DECISION DELEGATED TO DEVELOPMENT MANAGER

Application No: H16-0812-20 **Applicant:** Mr & Mrs Jeffery
Proposal: Proposed two storey extension & alterations
Location: Willowgate Cottage 2 The Parkway Spalding
Terminal Date: 19th November 2020

CASE OFFICER ASSESSMENT

Front Elevation
PROPOSED Elevations 1:100

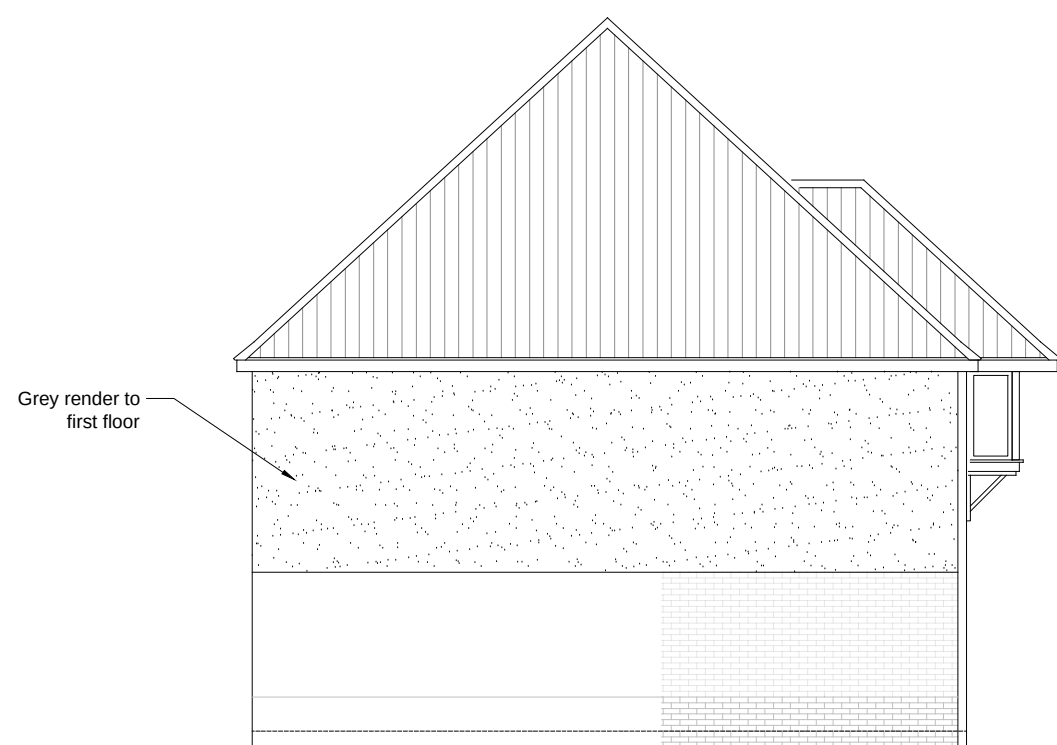
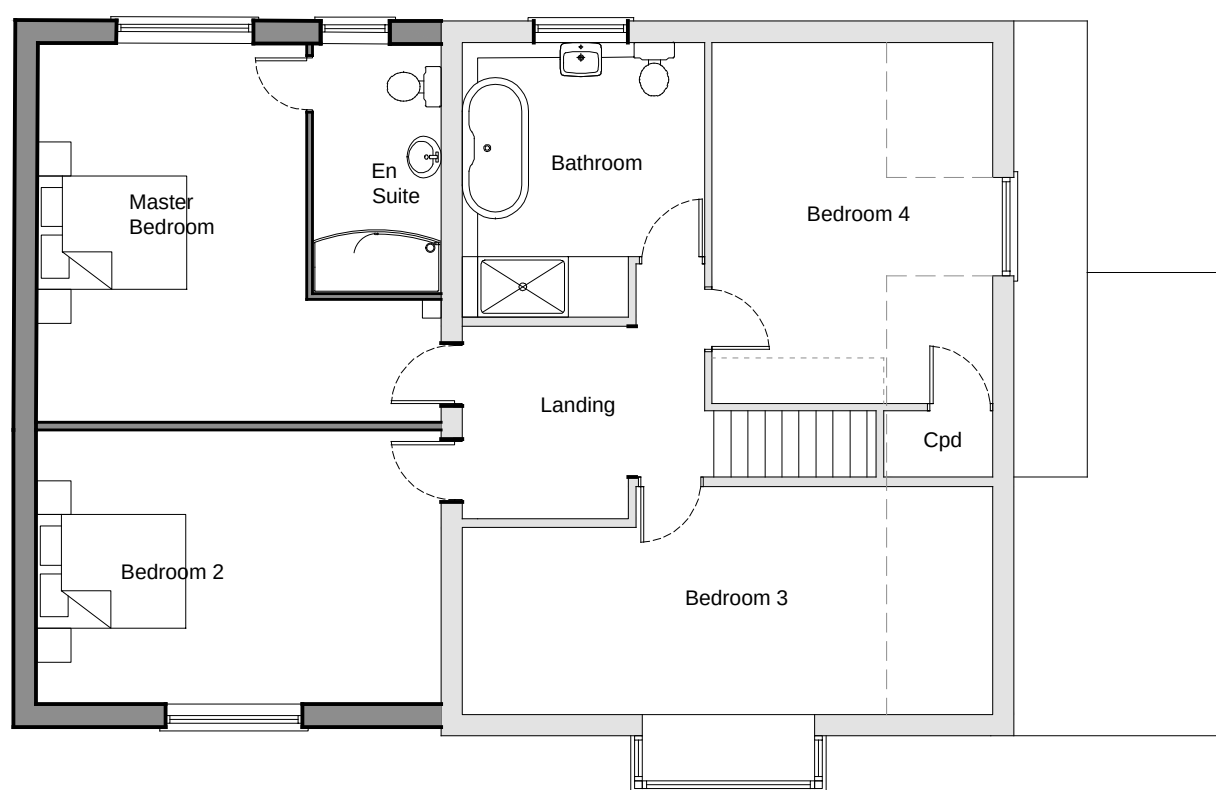
The existing patio and detached garage will be removed in order to ease floorspace for the intended development. The proposal include re-roofing works which entail the increase of hip pitch in 2.15 metres. The proposed extension will protrude 5.65 metres from the north-western wall of the house. It will extend the full depth of the building. The apex height will raise up to 9.65 metres and the eaves will be as high as those in the house. The extension will be subservient to the host property in terms of scale, mass and bulking.

Re-roofing works will increase the heights of the full roof structure and reposition the ridgeline that will extend side to side. Instead of the total length of the roof slopes, the hip ends will be visible on both side elevations. The existing hip roof overhang will remain as well as the bay window underneath. Likewise, the dormer window on the south-eastern roof slope will not result altered neither the 'saltbox' roof slope on that elevation.

Overall, the proposals will harmonise the roof layout externally. The increase of the roof pitch might appear excessive for a standard two-storey dwellinghouse. However, the eclectic features observed on the wider streets scene will not make the high pitch at odds with the surroundings. For instance, No. 12 is a two-storey bungalow with a very pointed and high gable pitch across the full building. The gable pitch on the adjacent property No. 10 is also of similar height.

Initially, the increase of the apex height caused some concerns with regards to its impact upon the adjacent bungalow to the north-west (No. 4). However, the proposed material increase is deemed acceptable.

Having checked the planning history of the adjacent property No. 4, no habitable spaces adjoining the elevation opposing the proposed extension. There are currently two windows of small scale which lighten one bathroom and one en-suite. No upper windows will be opened on the side elevation of the extension, thus no overlooking impact will occur.

Concerning the other adjacent property at No.19 Amstel Close, two upper windows will be created on the rear elevation of Willowgate Cottage. They will be obscuring glazing and serve one bathroom and one en-suite which both are non-habitable spaces. In addition to the separation distance, such features are acceptable to the extent which no overlooking will occur upon No.19 Amstel Close through these additional windows.

Both properties are oriented to south-west. The increase of the roof pitch at such separation distance might cause some overshadowing especially in early times of winter period. However, it is not considered to be excessive and the nearest rooms are not habitable. On balance, it is considered that the development will not cause unacceptable overshadowing onto No. 4.

The fact that the hip end faces No. 4 will somewhat mitigate the visual impact of the increase upwards. The hip pitch might potentially appear less overbearing than perceiving the full length of the main roof slope.

In conjunction with Policy 36 of SELLP 2019, Appendix 6 sets out the minimum standards for parking provision upon the use class. The additional bedroom proposed would increase the total number of bedrooms from 3 to 4. Three spaces for dwellings with 4 or more bedrooms should be provided within the curtilage.

After carrying out the site visit, it is confirmed that two cars can be parked in tandem and one further across if required. Additionally, the block plan submitted demonstrates that the dimensions of the front part of the site are sufficient to accommodate such number of spaces.
